**RE: Australian Turf Club MP10\_0097 MOD 2**

Thank you for the opportunity to comment on the Australian Turf Club's application regarding the Spectator Precinct at Royal Randwick Racecourse. The Heritage Division provides the following response on behalf of the NSW Heritage Council.

Figure 3: Proposed Location Zones of Temporary Structures- Shown in Pink (Source: proponent's S75W Report)

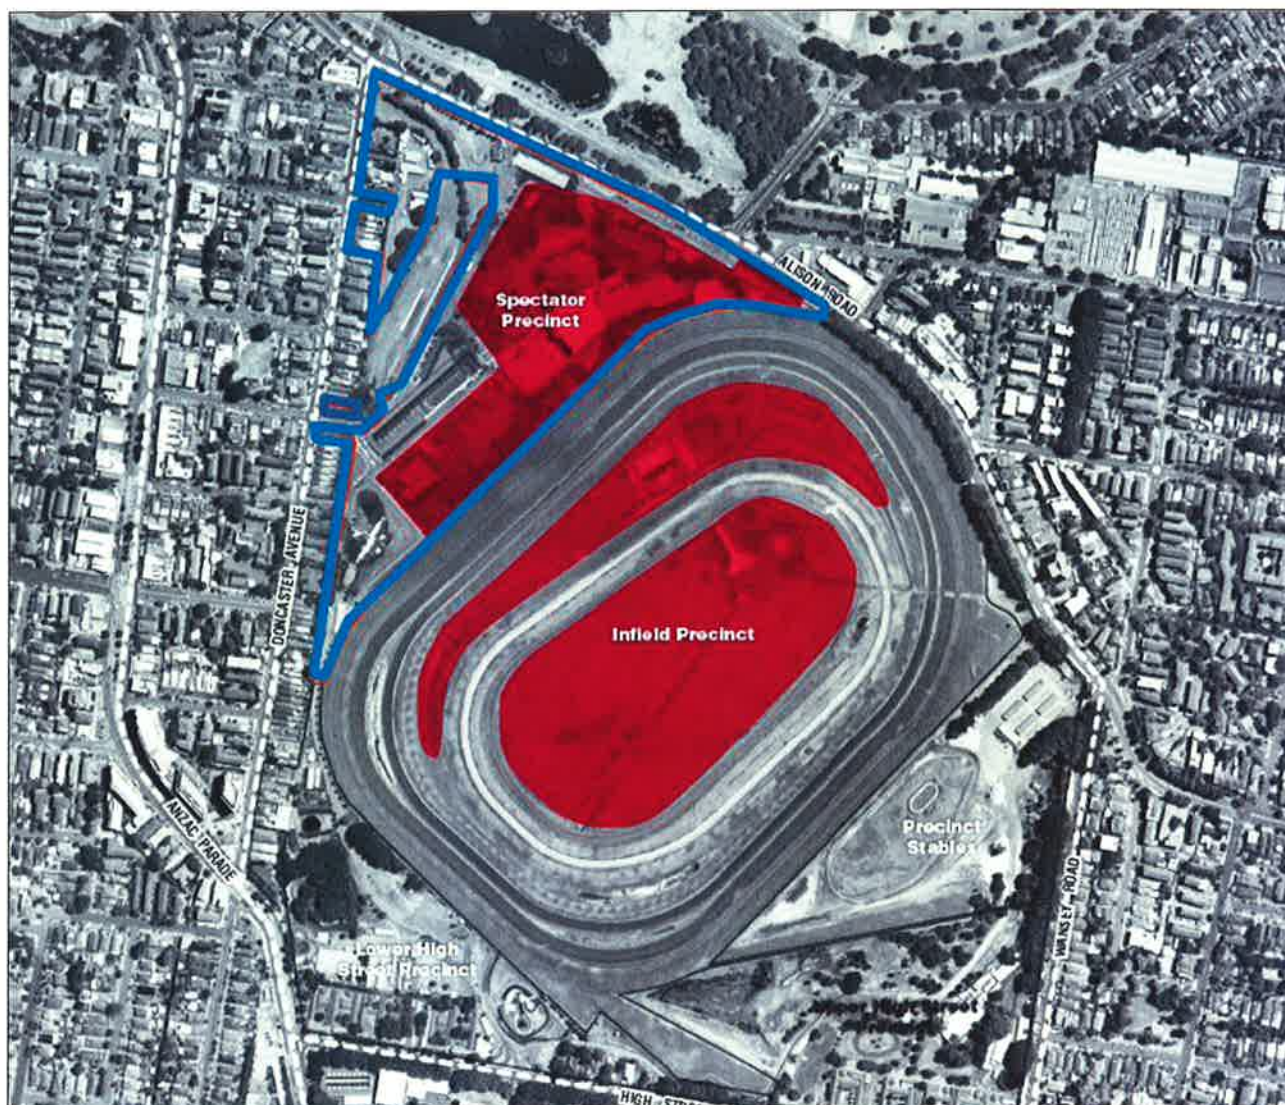
- In relation to the location of the proposed temporary structures, the applicant should be required to provide expert advice as to whether the erection of temporary structures, in the proposed areas as shown on Figure 4 of the Environmental Assessment, is likely to impact on archaeological relics/deposits. Suitable mitigation strategies should be devised if there is likely to be an adverse impact on archaeological resources.
